RE: Love's Travel Stop SEPA (SE-19-00014)

Enclosed are the comments received regarding the SEPA Checklist (SE-19-00014) during the comment period which ended November 29, 2019 at 5pm:

PRELIMINARY STORMWATER PLAN
LOVE'S TRAVEL STOPS
EASTON, WA

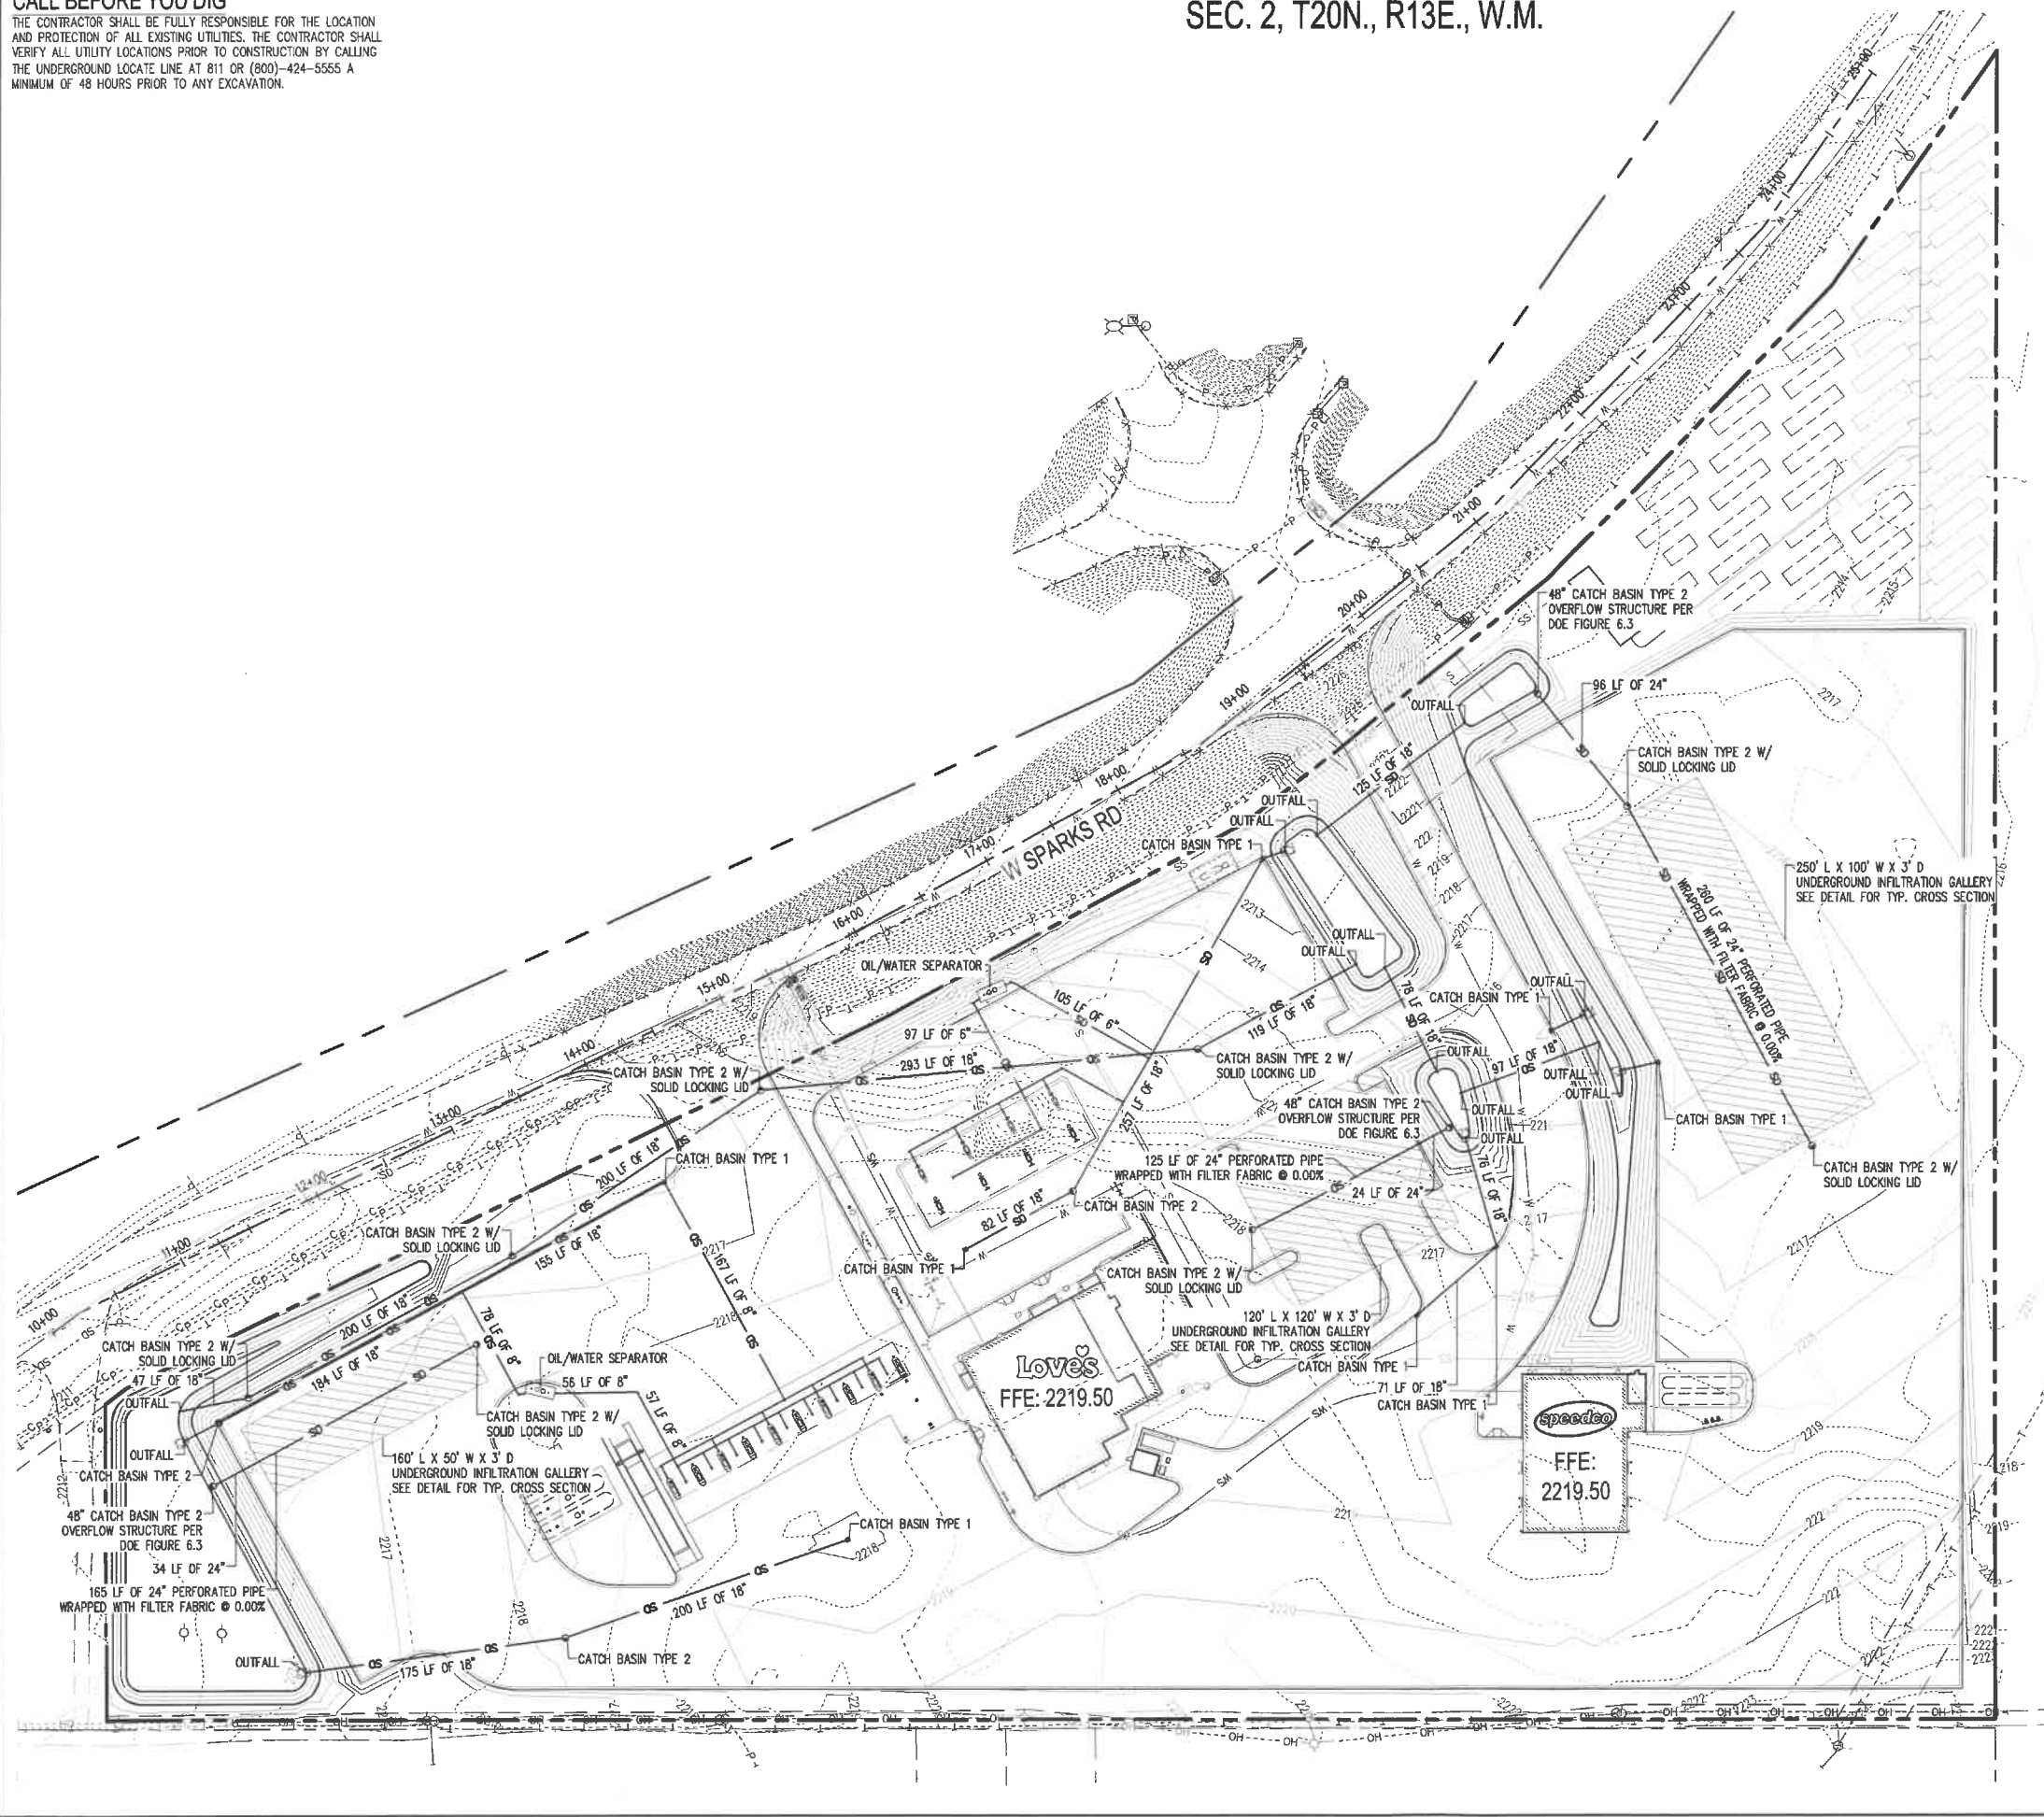
4. Public Works will review the stormwater plan for the site once a plan (sealed by a professional civil engineer in the State of WA) is received for review.

1) The answer to this question requires additional information also. There is no statement describing the source of runoff or the method of collection and stated treatment. I also believe there should be an estimated quantity included. The fact that 74% of the proposed development will be impervious should require some detailed estimates of septic and stormwater quantities to be infiltrated in to the remaining 26%.

2), 3) Stormwater runoff in the Easton area can be a problem during times of snow melt and can cause flooding and standing water if the system is not designed adequately. Inadequate control of stormwater on such a large impervious area could cause local flooding and possible runoff on to abutting properties. Untreated runoff could likely contain large amounts of commercial de-icer and snow melt chemicals. Any petroleum products and other hazardous materials which may have been deposited over the winter months when detecting, containing and cleanup of would also by pass any treatment process and be deposited in unintended areas.
